**SINGLE + TWO STOREY EXTENSIONS AND INTERNAL ALTERATIONS  
WEST FARM COTTAGE, SIBFORD GOWER**

Further to my email correspondence with George Smith (Senior Planning Officer) between 1<sup>st</sup> - 23<sup>rd</sup> June 2021, we hereby enclose the following documents in PDF format in order to make a variation of condition application to planning permission 20/03601/F:

DETAIL 04
UTILITY WINDOW DETAILS
SECTION
1:20

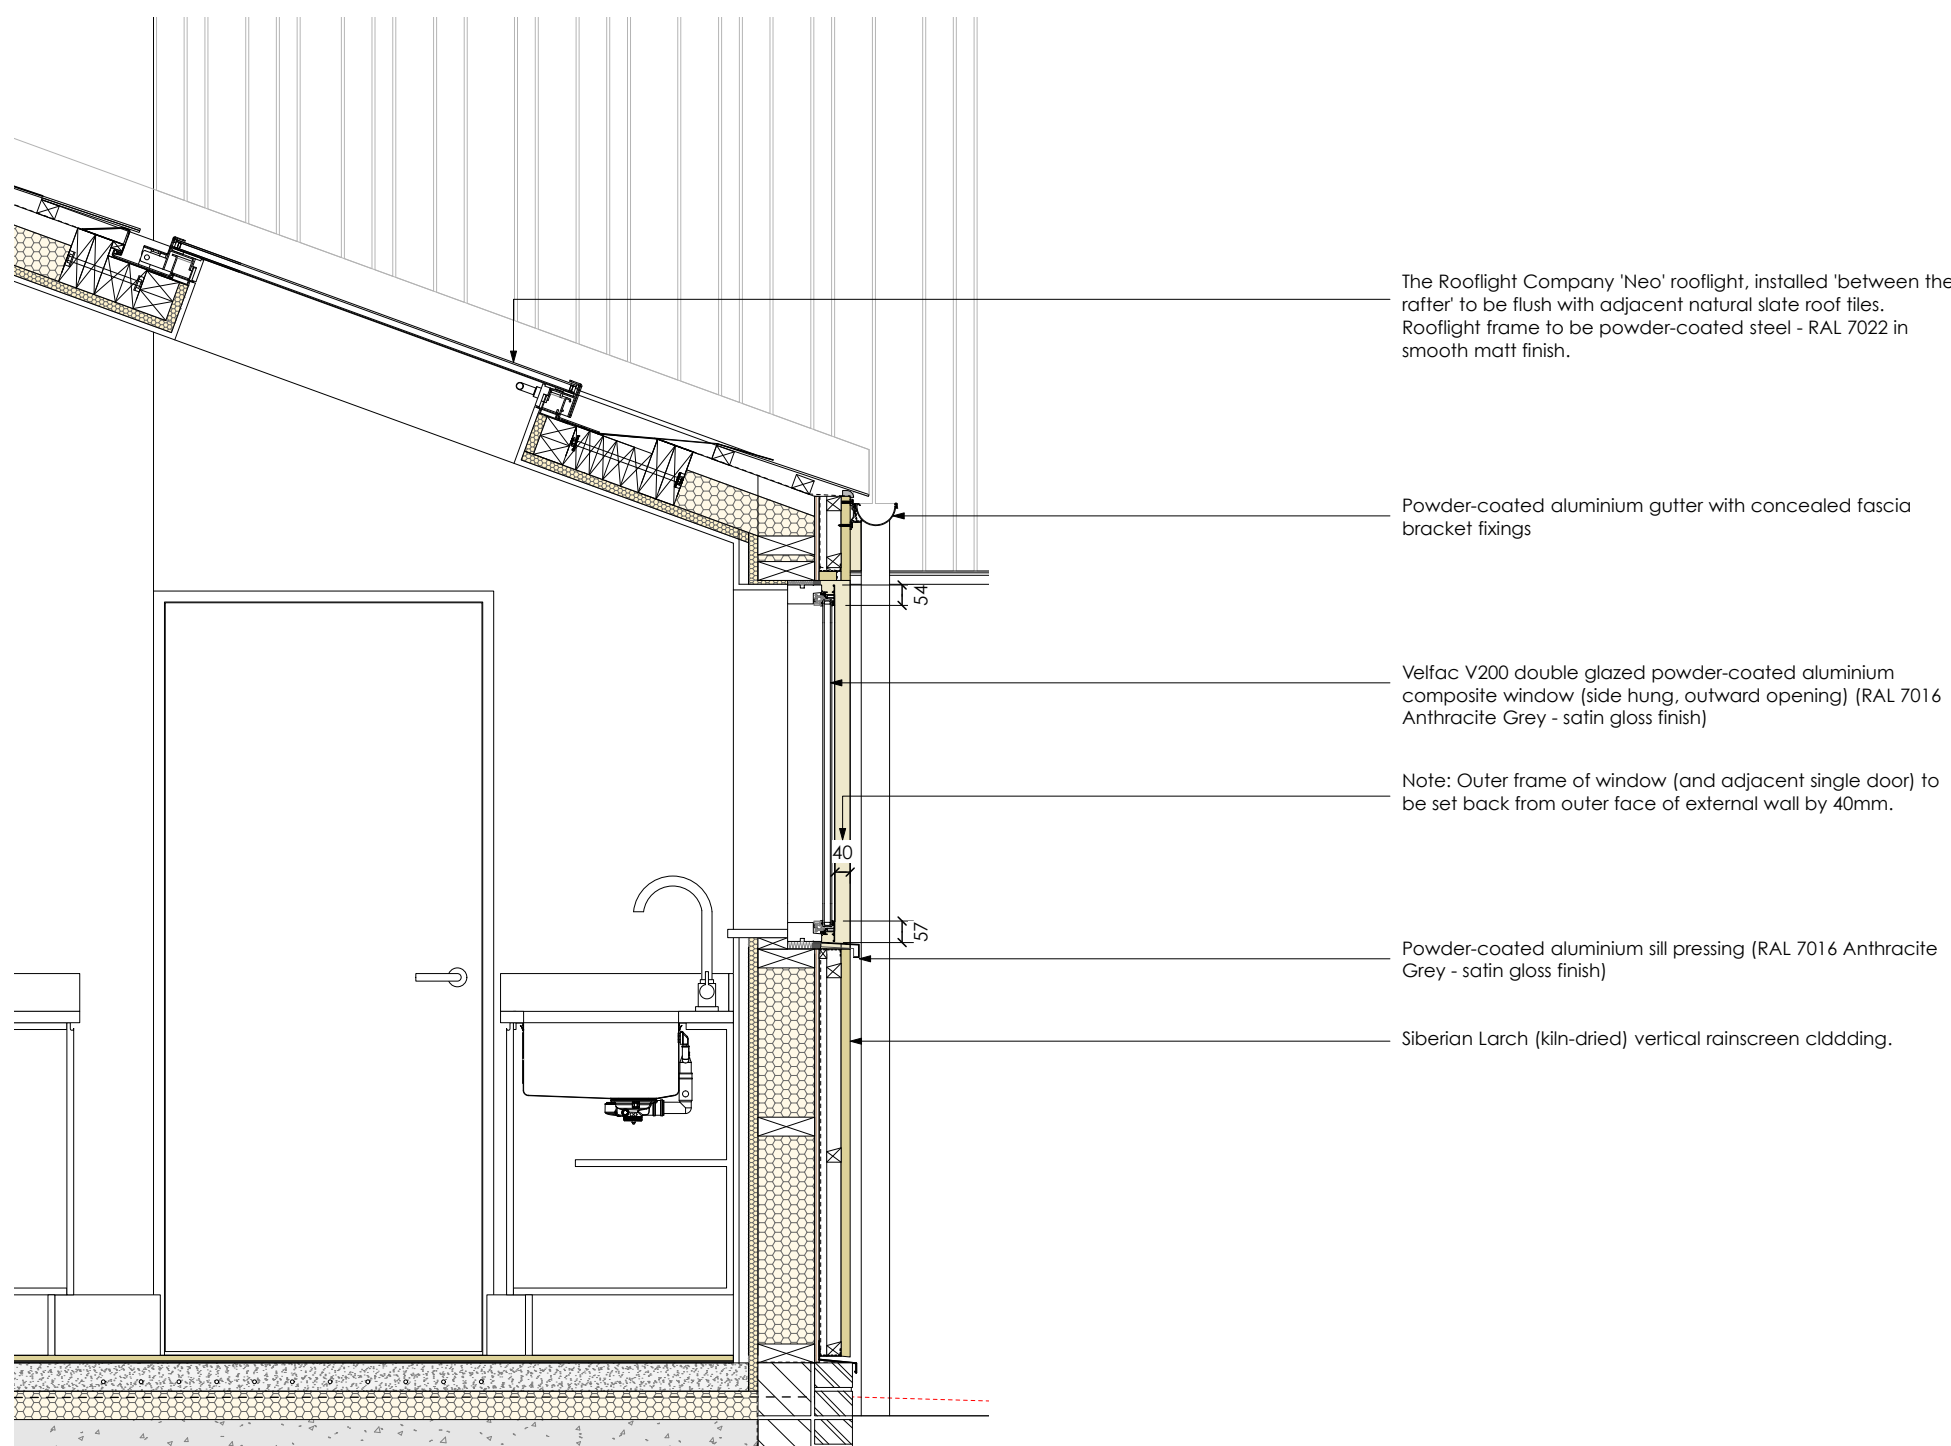
We wish to replace drawing 19\_076-102 with 19\_076-102A to reflect the amended glazing details to the two-storey extension and revised glazing specification for the window and door to the single-storey utility extension.

The replacement specification for a Velfac 'Ribo' glazed inward opening door to the utility extension is identical in terms of detailing and dimensions to the previously approved Rationel 'Auraplus' inward opening glazed door, however, we have switched supplier to Velfac to use a slimmer framed window ('V200') to the north elevation of the utility extension than the Rationel 'Auraplus' previously approved.

Revisions:		
A	18/12/20	Rooflight added to two-storey extension for Planning.
B	11/08/21	Amendments to two-storey extension, including omission of lift tower, revised glazing arrangement and vertical timber rainscreen cladding to first floor.

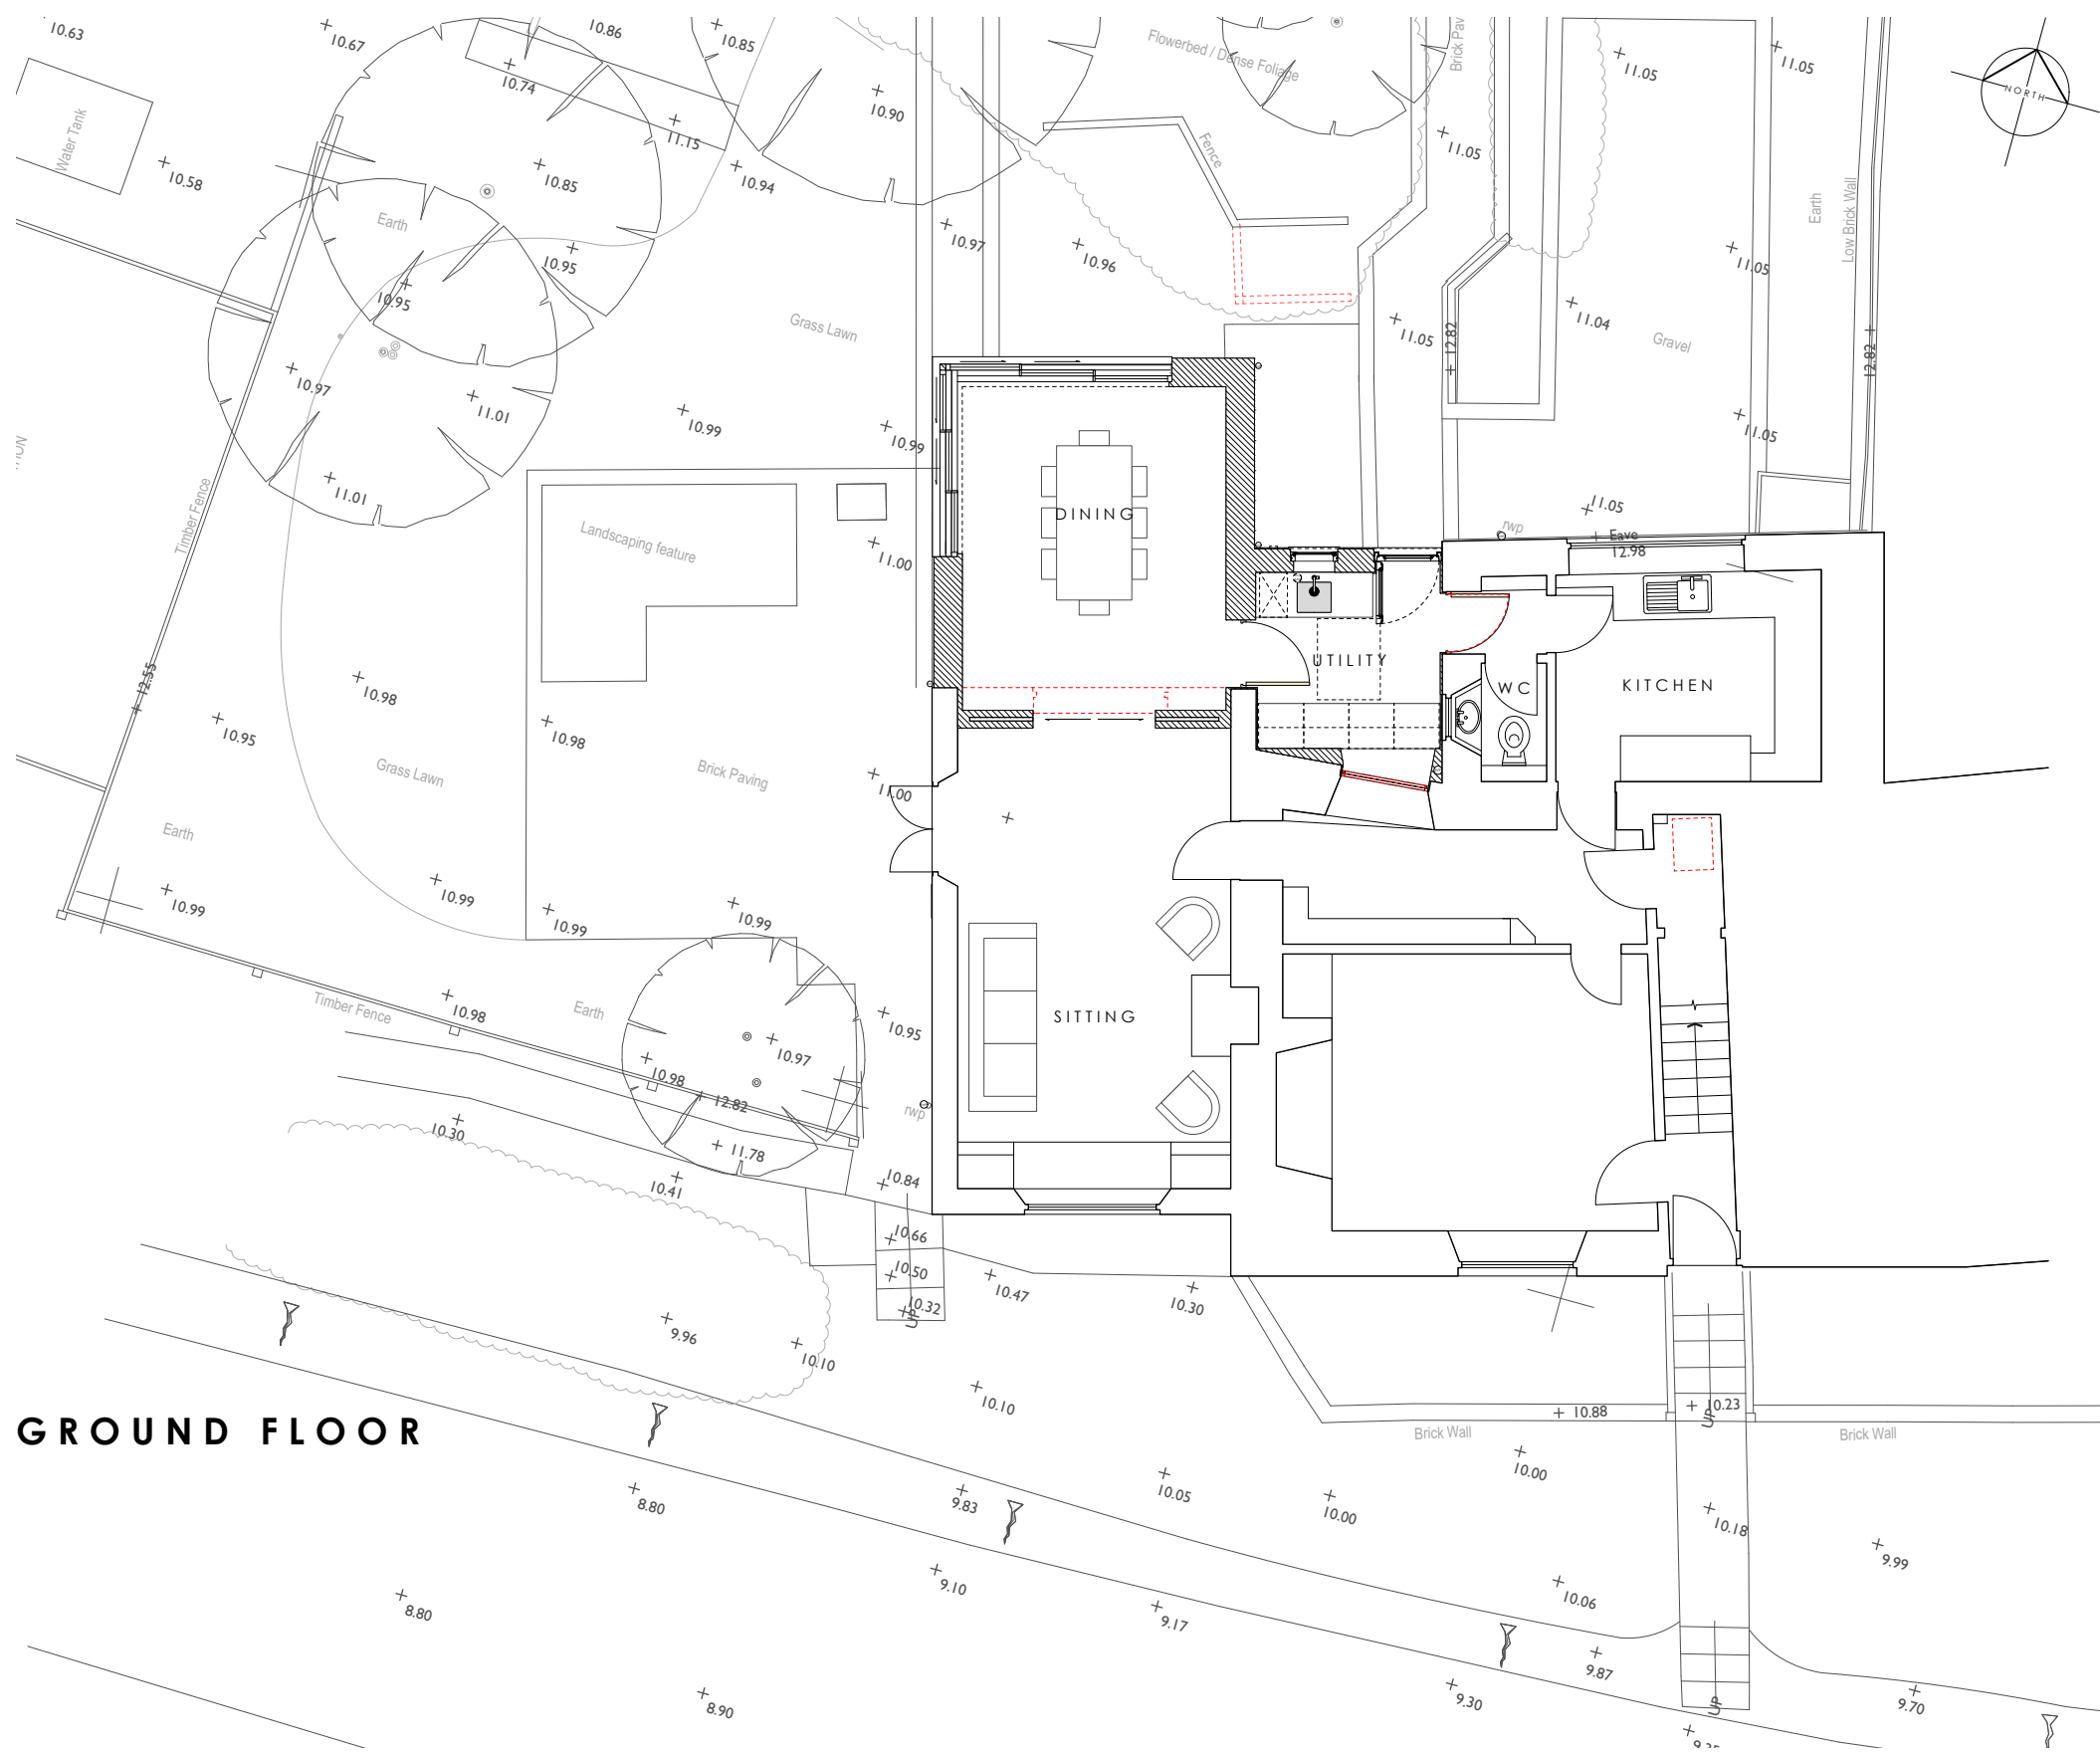
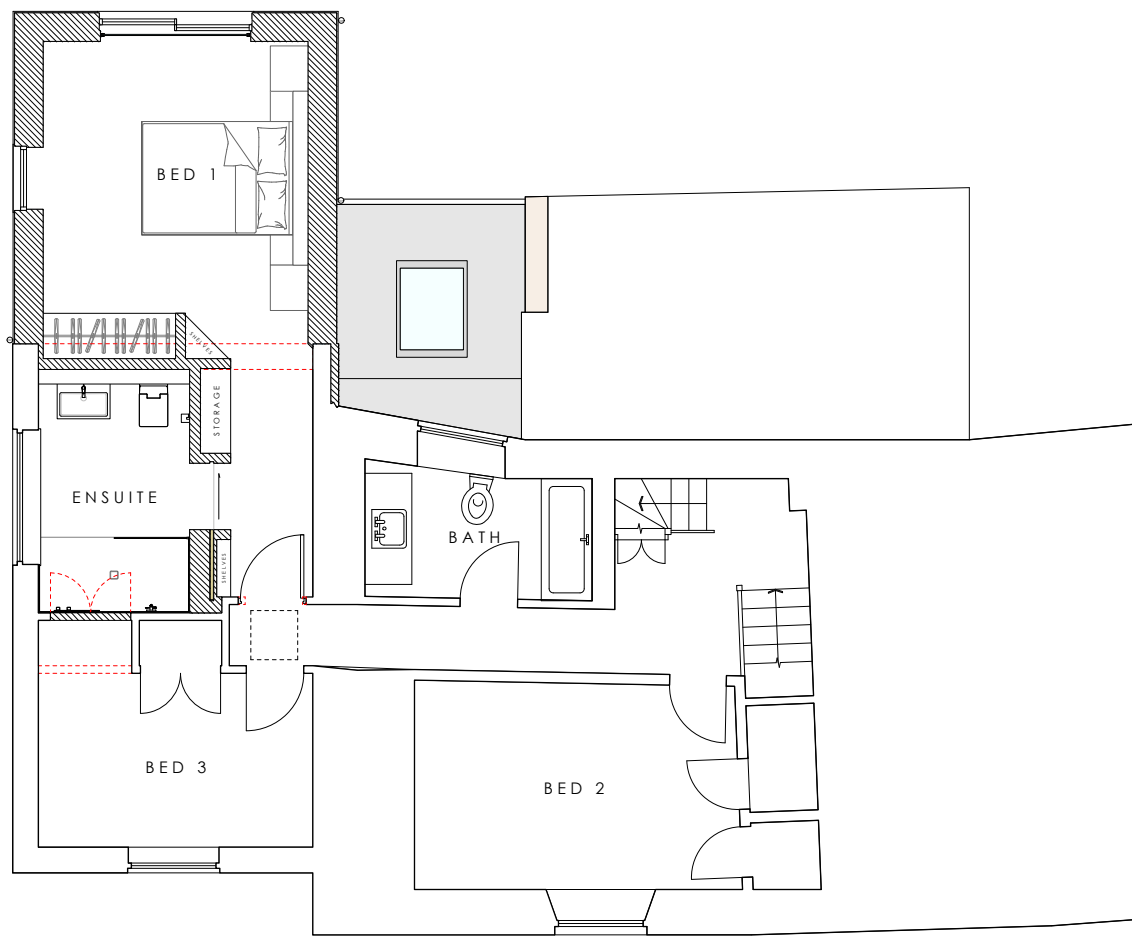
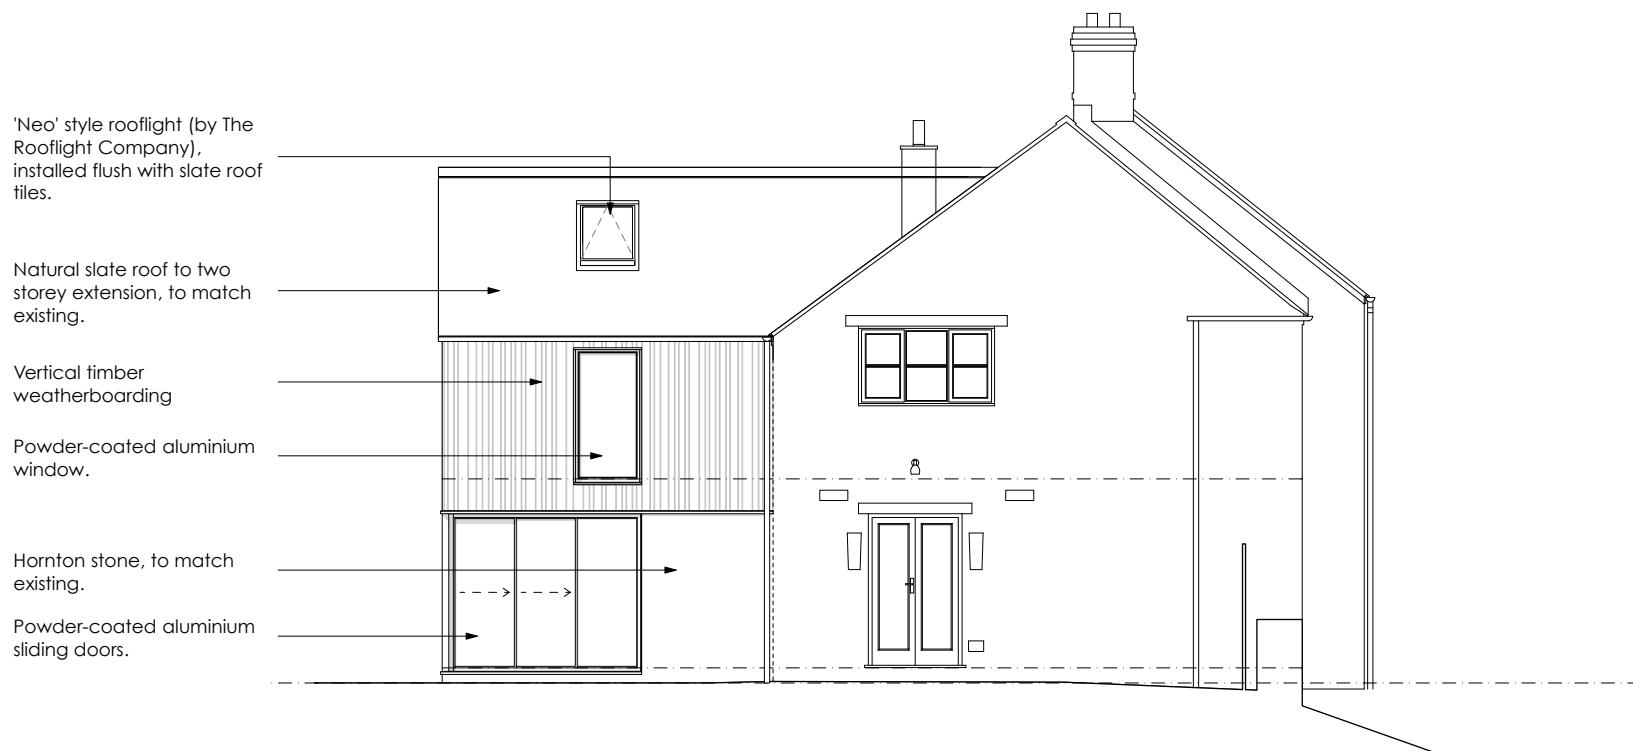
We wish to replace drawings 19\_076-100A with 19\_076-100B and 19\_076-101A with 19\_076-101C, to reflect the amendments to the approved two-storey extension, as discussed with George Smith.
